Date 4 March 2022  
Our Ref 22/00171/CLP

**Town and Country Planning Act 1990 (As Amended)**  
**44 Highfield Drive, Ewell, Epsom**  
**Single storey side extension**

Drg. No. HD 1

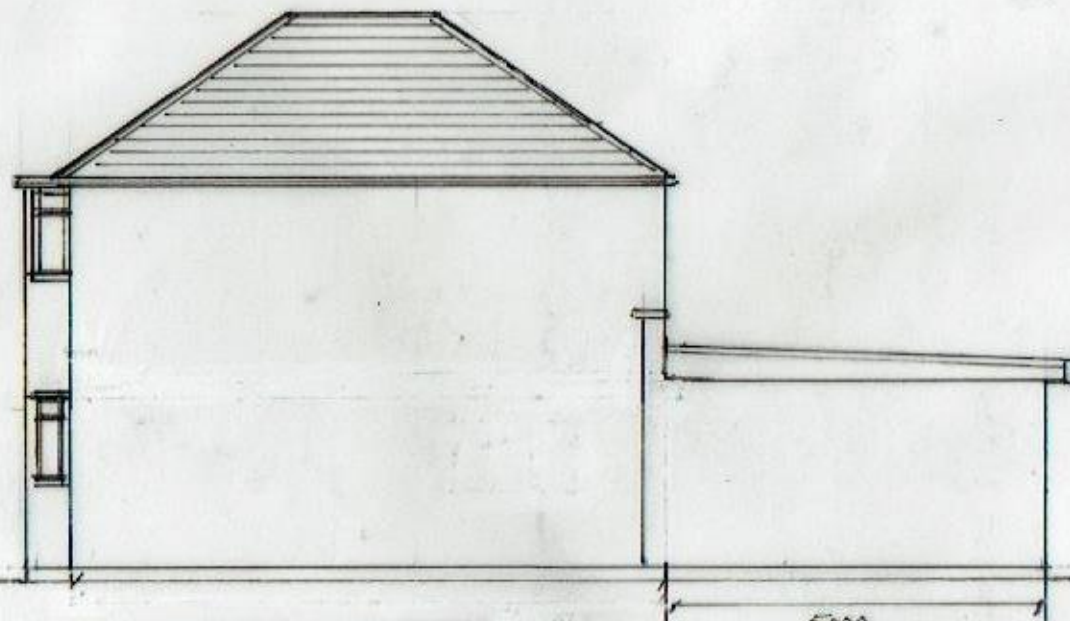
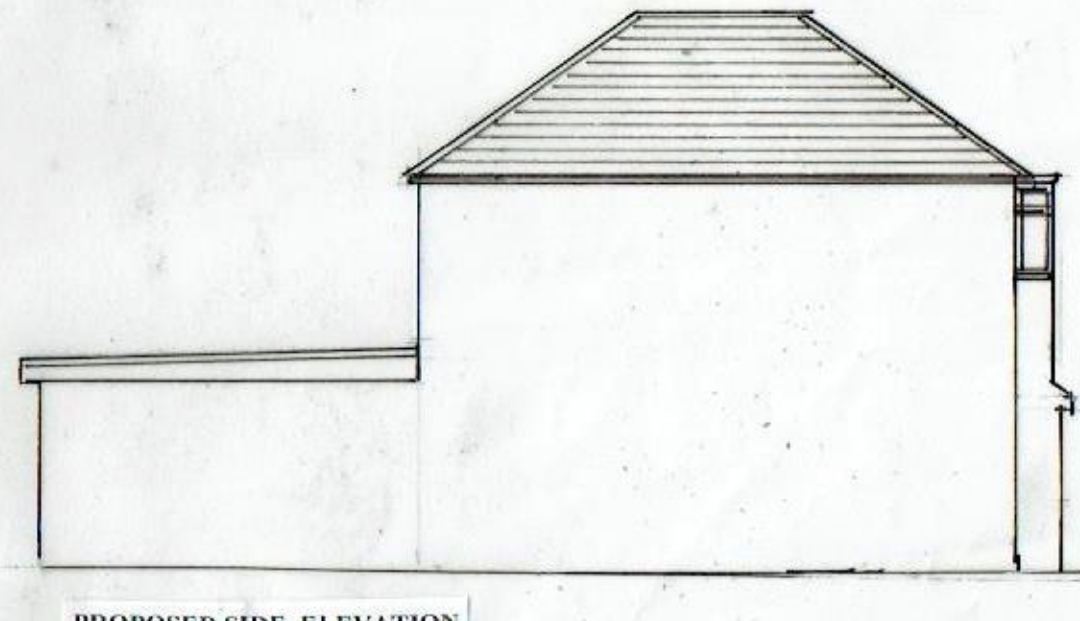
1 The applicant has stated the proposed extension has single storey rear extension, however, the submitted proposed plans are showing single storey side extension. Please either provide a correctly filled application form or provide drawings that reflect rear extension rather than the side extension.
